Our reference: P-325302-P2T8  
Contact: Gavin Cherry  
Telephone: (02) 4732 8567

1 July 2022

**Nepean Hospital Redevelopment Project - Stage 2 - Response to Submissions (SSD-16928008) 35-65 Derby Street, Kingswood**

Figure 21 - Proposed Drop-off area and access driveways

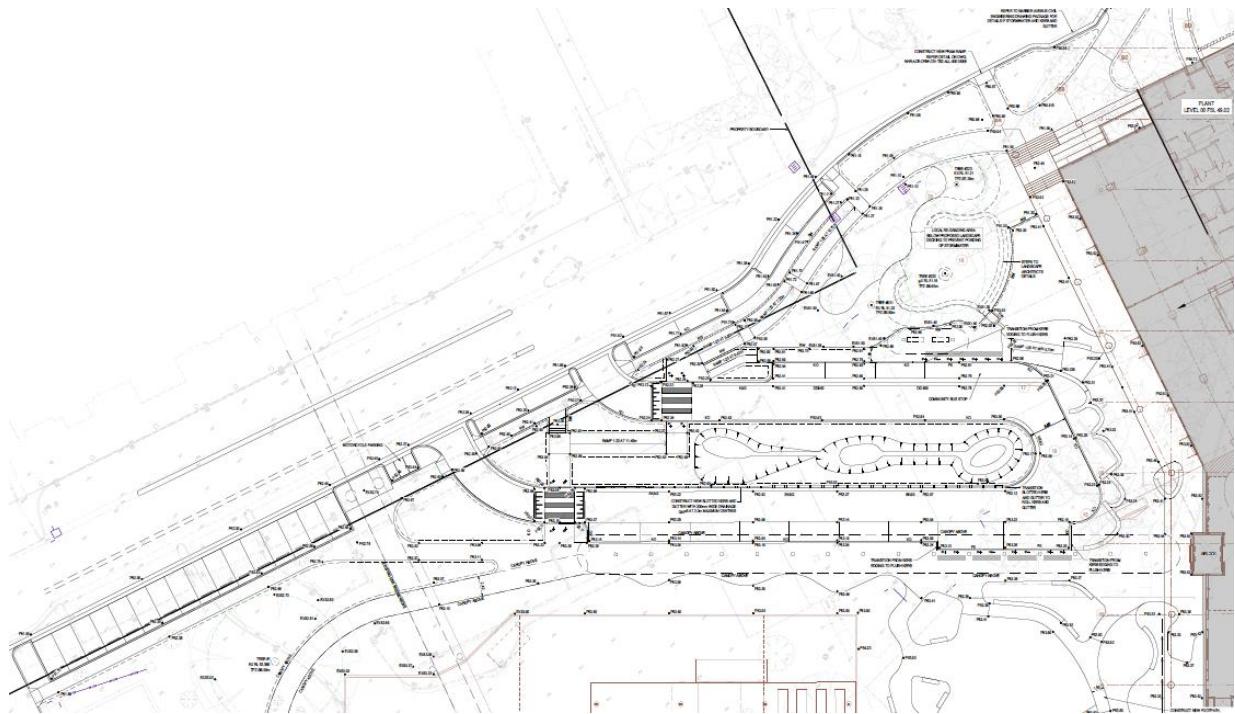
- I. The proposed removal of on-street parking in Barber Avenue is still not supported due to unrestricted parking being in high demand around the hospital precinct. There are currently 38 x 2P parking spaces on Barber Avenue east of Parker Street (34 x on the south side of Barber Avenue and 4 x on the north side) and the plans propose to only retain 2 spaces and reinstate 22 spaces, resulting in a net loss of 14 x 2P parking spaces which is an unacceptable loss within Council's infrastructure and cannot be supported.

- II. All alternative design options must be explored to maximise the retention of on-street parking, including combining the proposed ingress and egress driveways for the front of house area, reducing the landscaped area adjoining the access driveways and relocating the private pedestrian ramp out of the road reserve to retain additional on-street parking.

- V. It is unclear why widening of Barber Avenue is proposed as this will impact existing on-street parking spaces. The infrastructure within the road reserve is under Council's control and management and shall be retained.

- VI. The proposed new parking spaces along the southern side of Barber Avenue partially encroach the private property boundary which is not supported. Public parking shall be wholly contained within the road reserve.

- VII. All retaining walls, private pedestrian ramps and other private structures shall be wholly contained within private property and are not permitted within the Council road reserve.

Figure 4.2-C: Barber Avenue Adjustments

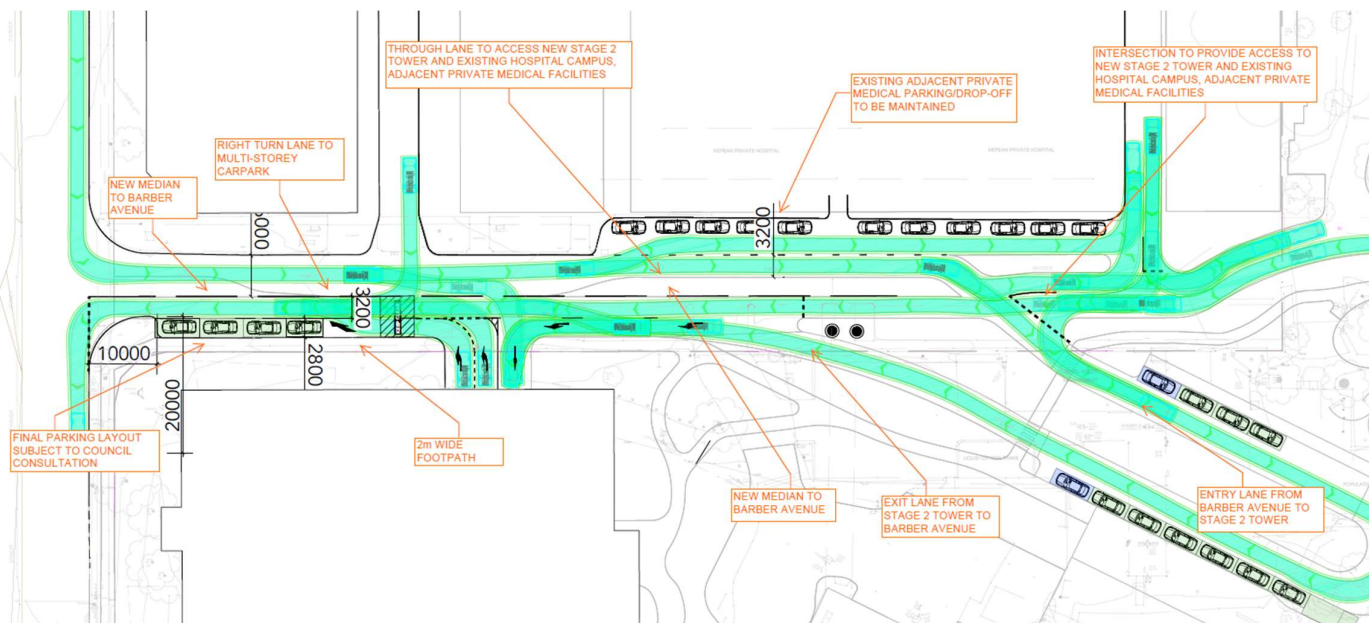
- VIII. The kerb and footpath at the western limit of works (i.e. at the driveway entrance the multi-storey car park) do not align with the existing kerb and footpath on the opposite side of the driveway entrance and need to be adjusted to suit, though it is unclear why widening of Barber Avenue is proposed per item 5 above which impacts existing infrastructure.
